Arun District Council
Arun Civic Centre
Maltravers Road
Littlehampton
West Sussex BN17 5LF
Planning & Building Control General Enquiries
Tel: (01903) 737756 Fax: (01903) 730442
Dx: 57406 Littlehampton
Minicom: 01903 732765
e-mail: planning@arun.gov.uk
website: www.arun.gov.uk/planning

Application No: A/48/22/RES
Site Address: Land off Arundel Road Angmering BN16 4ET
Description of works: Approval of reserved matters following A/122/19/OUT and varied by A/207/21/PL pertaining to the layout, scale, appearance and landscaping for 160 No dwellings. This application is a Departure from the Development Plan and is in CIL Zone 3 and is CIL Liabe as new dwellings.

Thank you for your internet representation made on 21st April 2022 which has been recorded as an objection with the comments as follows:

Parking distribution plan

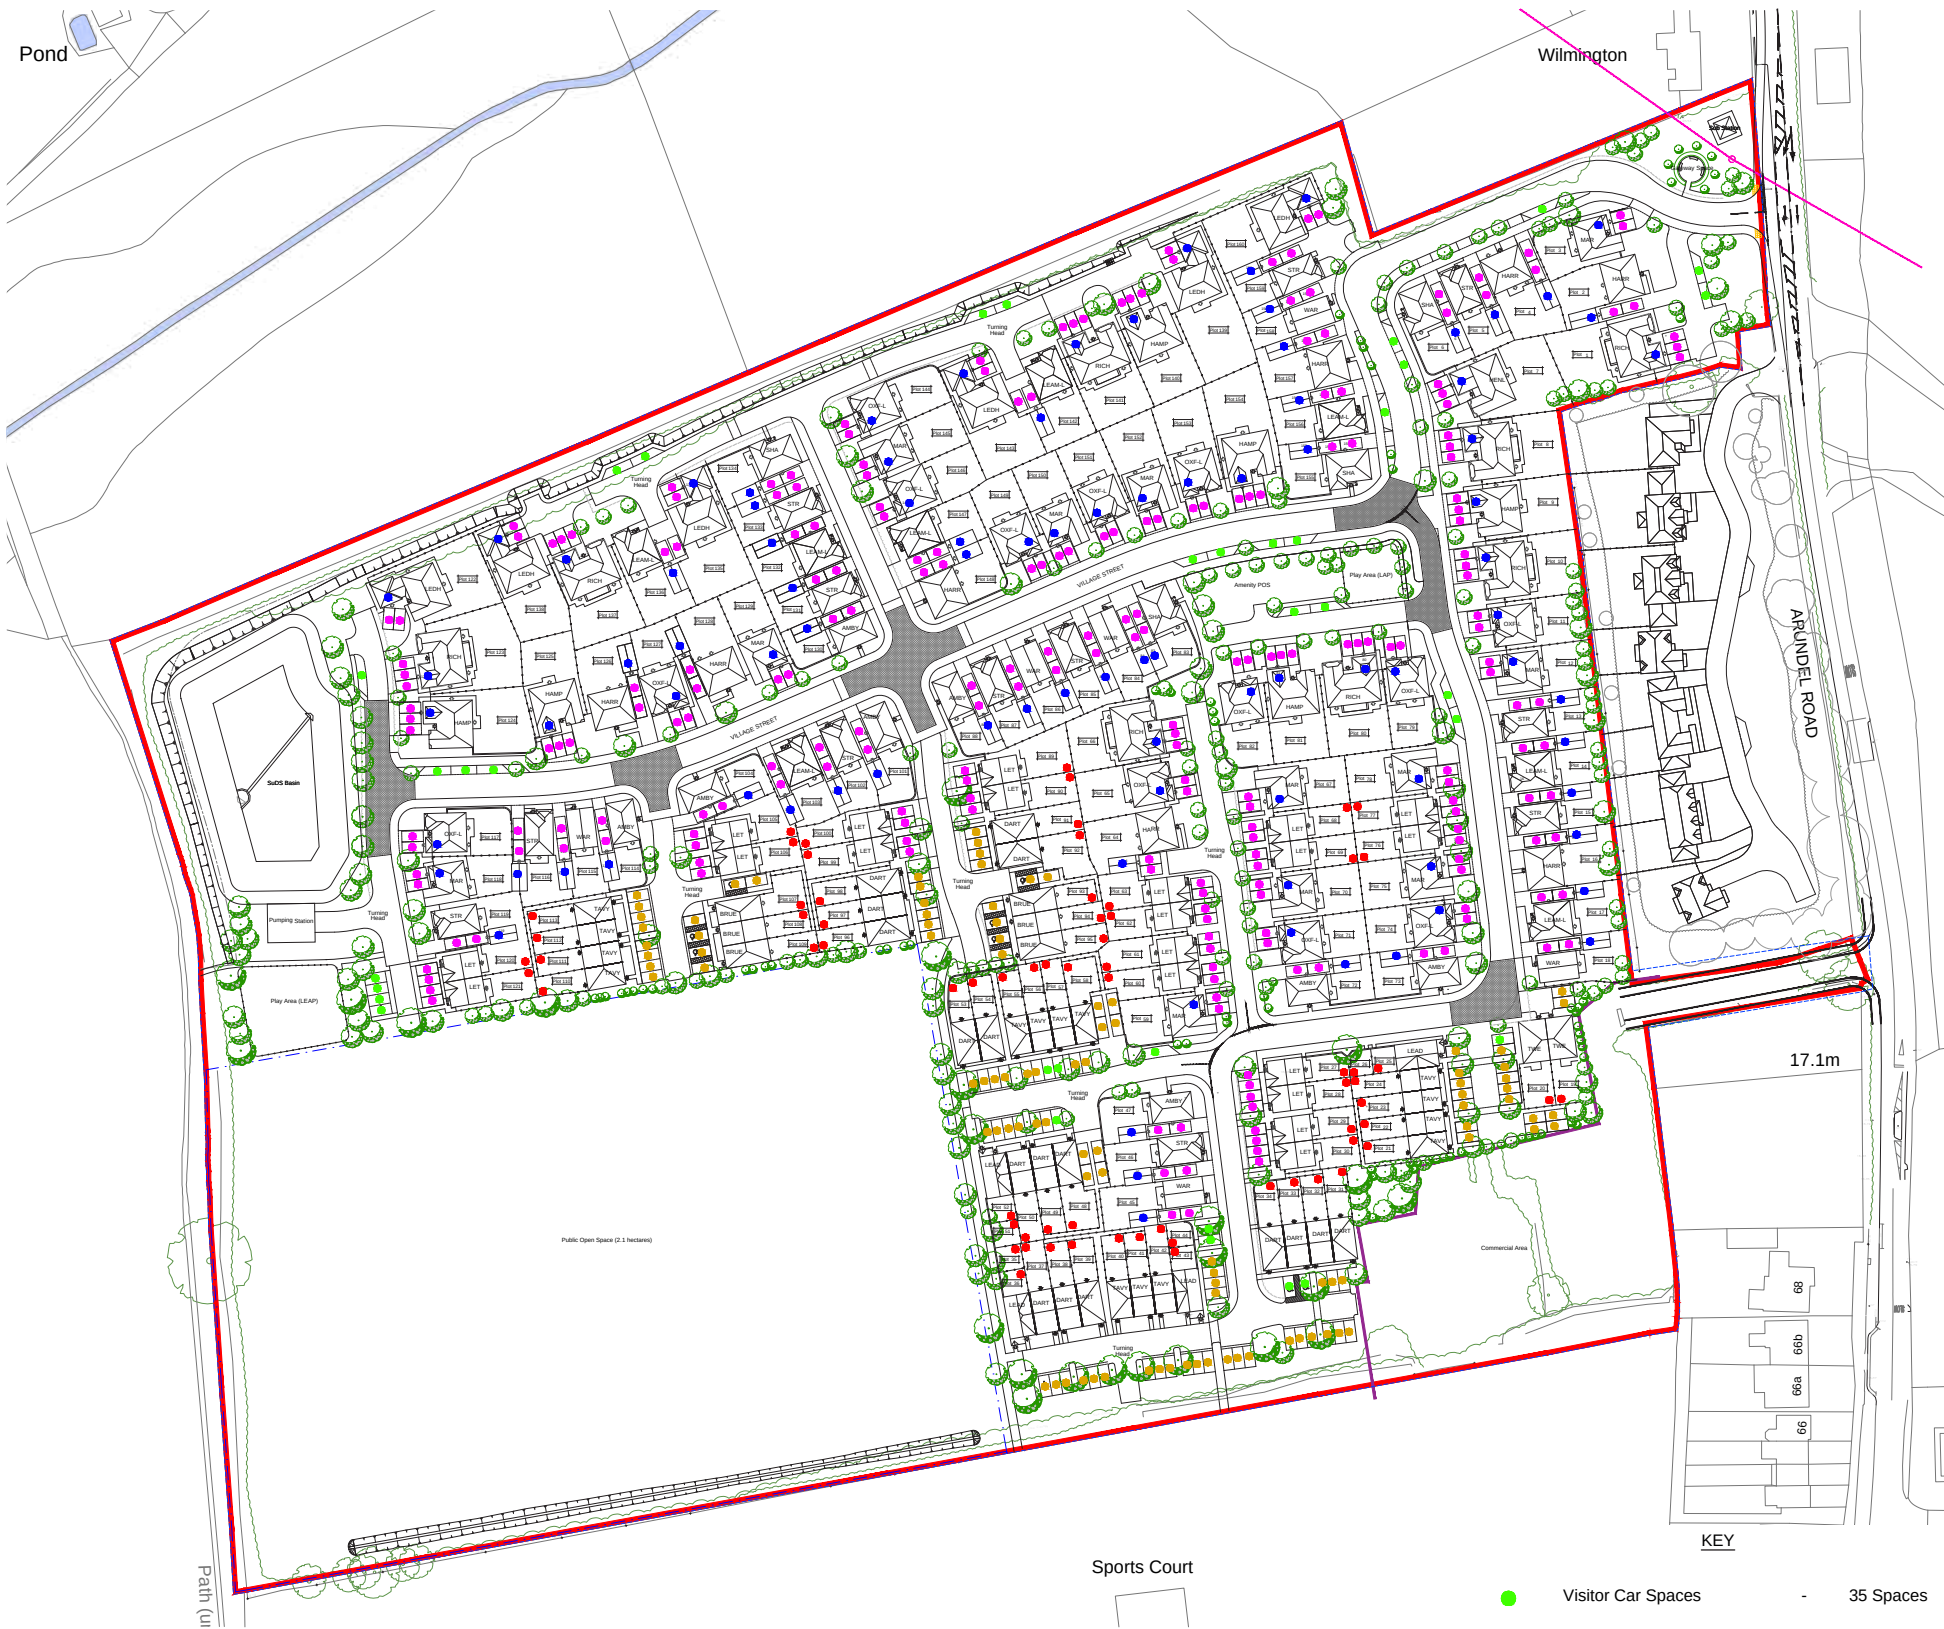
The proposed layout of the residential element of the site is cramped, dominated by on street and front of plot car parking and has insufficient space for the street trees shown on the plans or any other green infrastructure along the streets. As a result the scheme fails to provide high quality design reflecting local distinctiveness as required by Angmering Neighbourhood Plan policies HD5 and HD6.
